GRADING & EROSION CONTROL PLANS FOR:
LATIGO TRAILS
FILING NO. 10
 EL PASO COUNTY
 FALCON, COLORADO

**CONESTOGA TR.
 GRADING &
 ERSN CNTL PLAN**

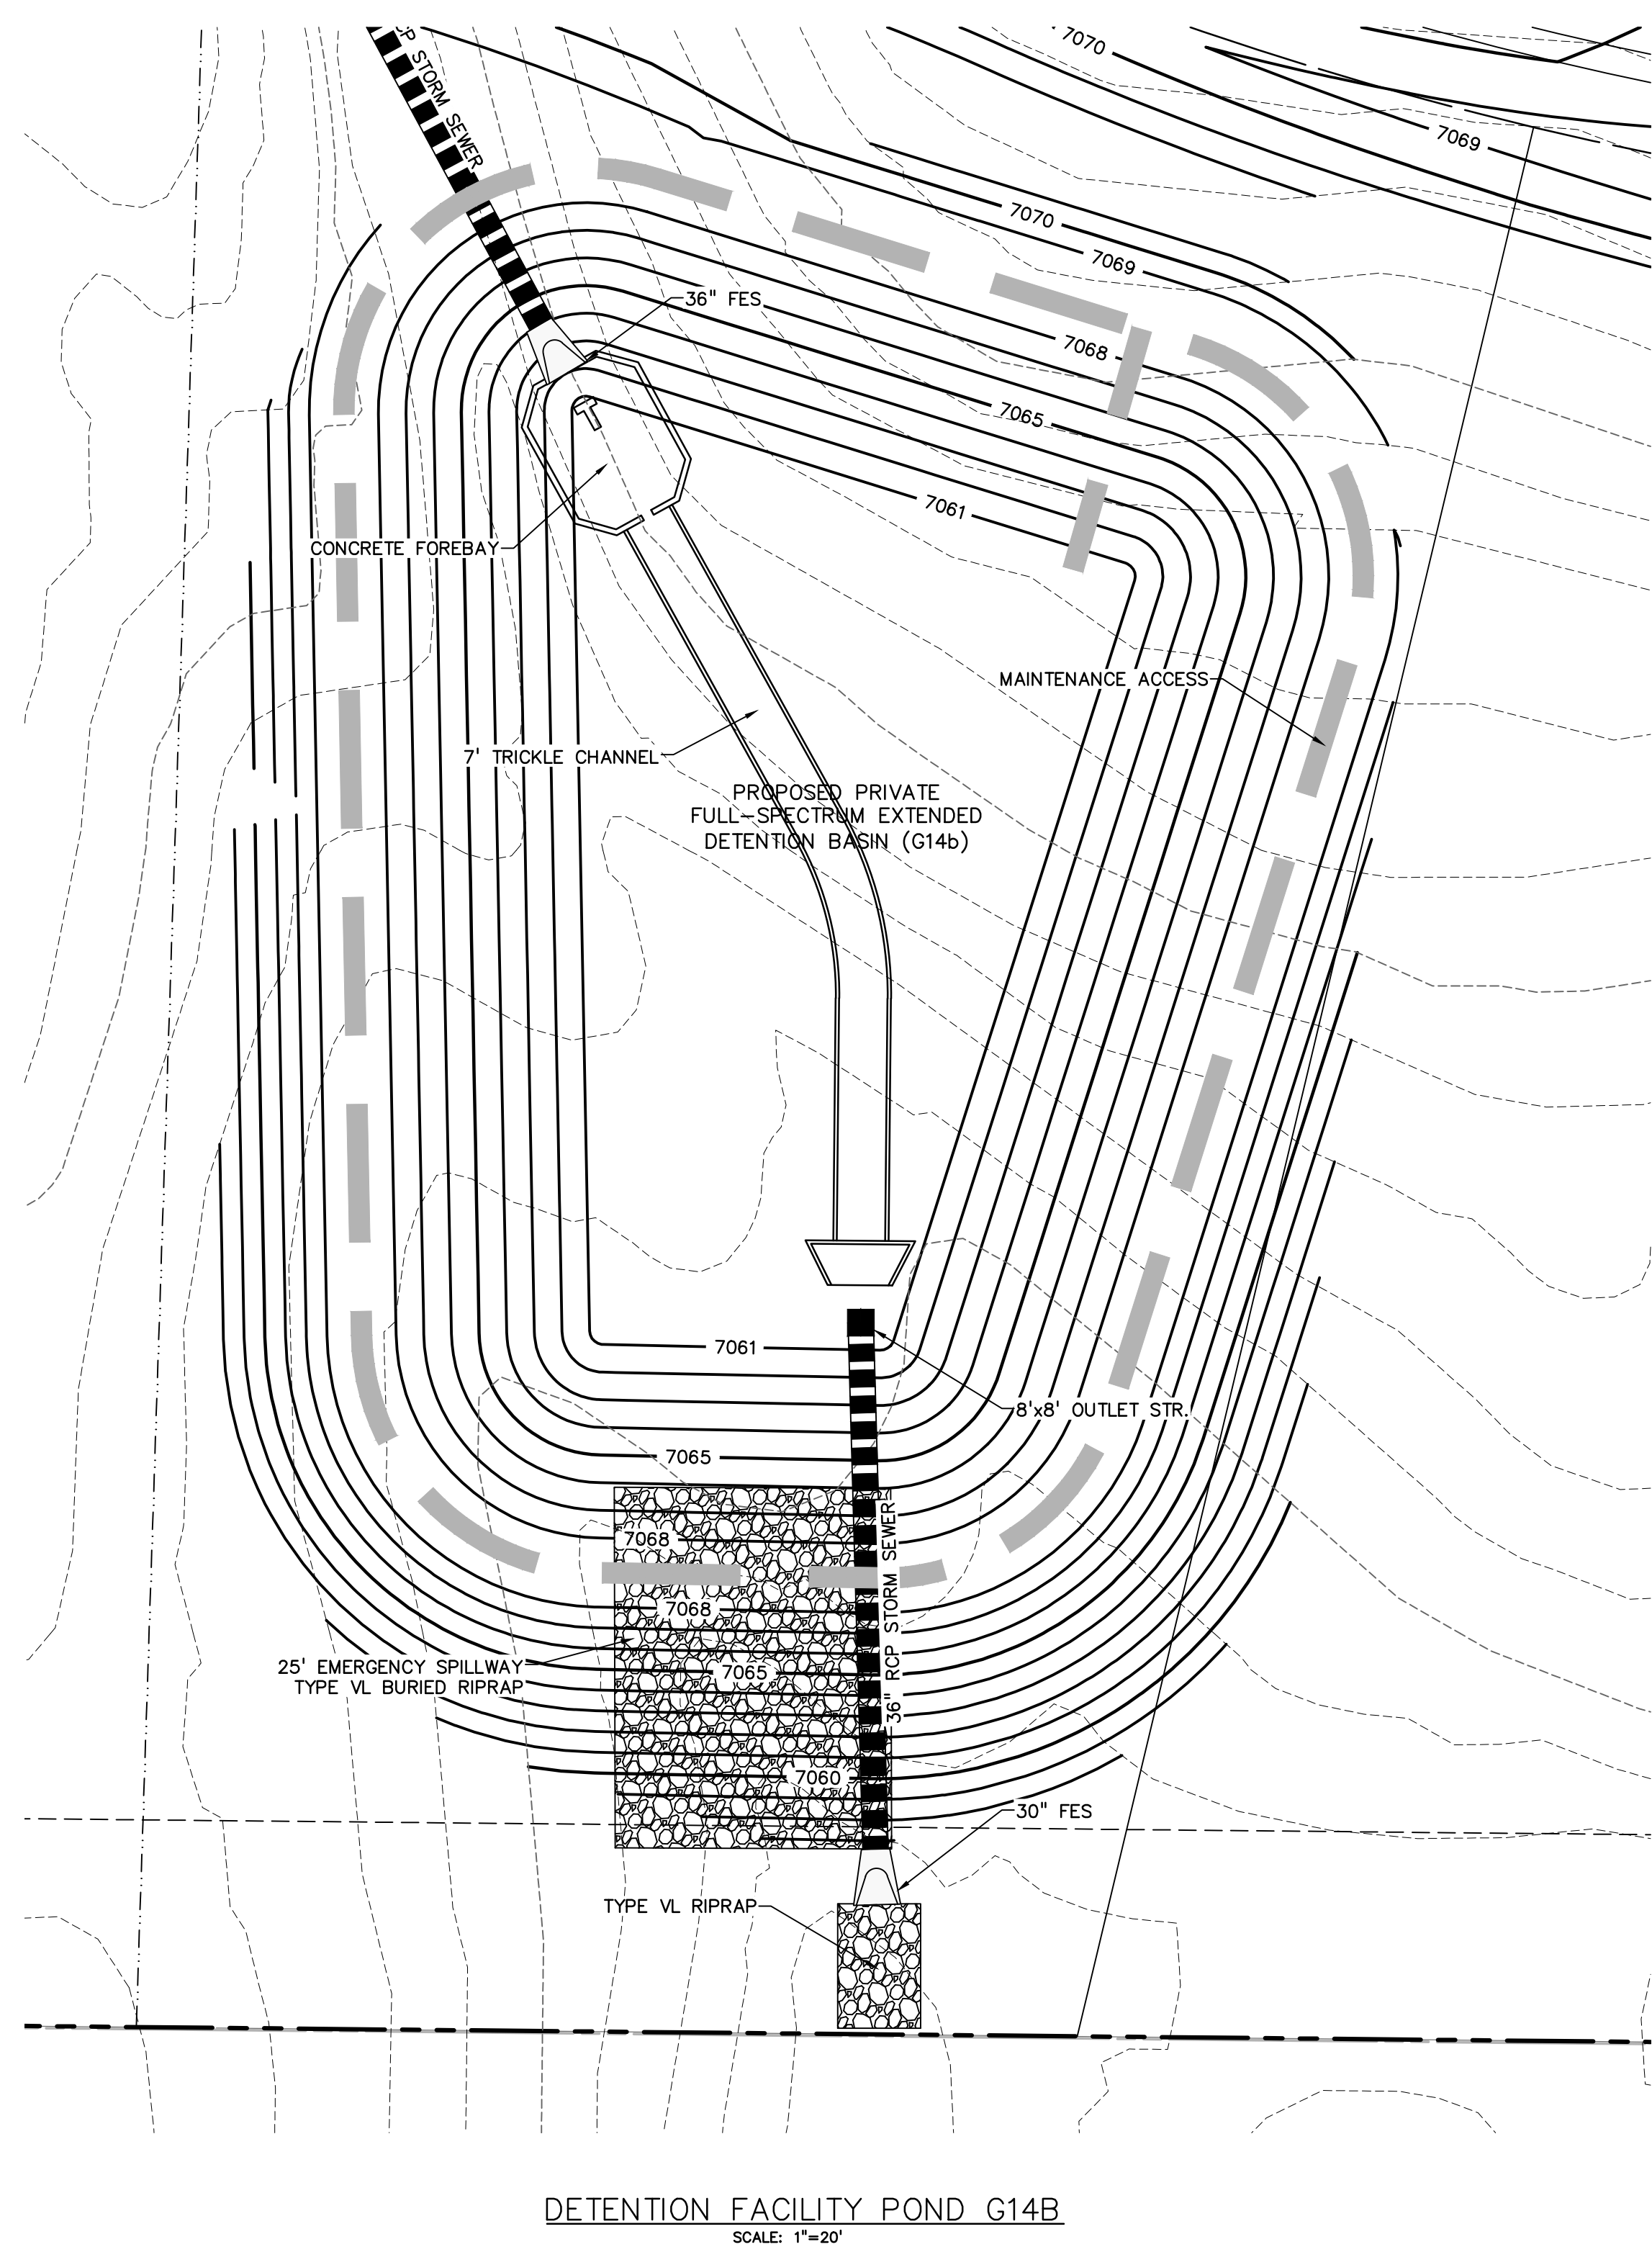
Provide seeding/mulching details
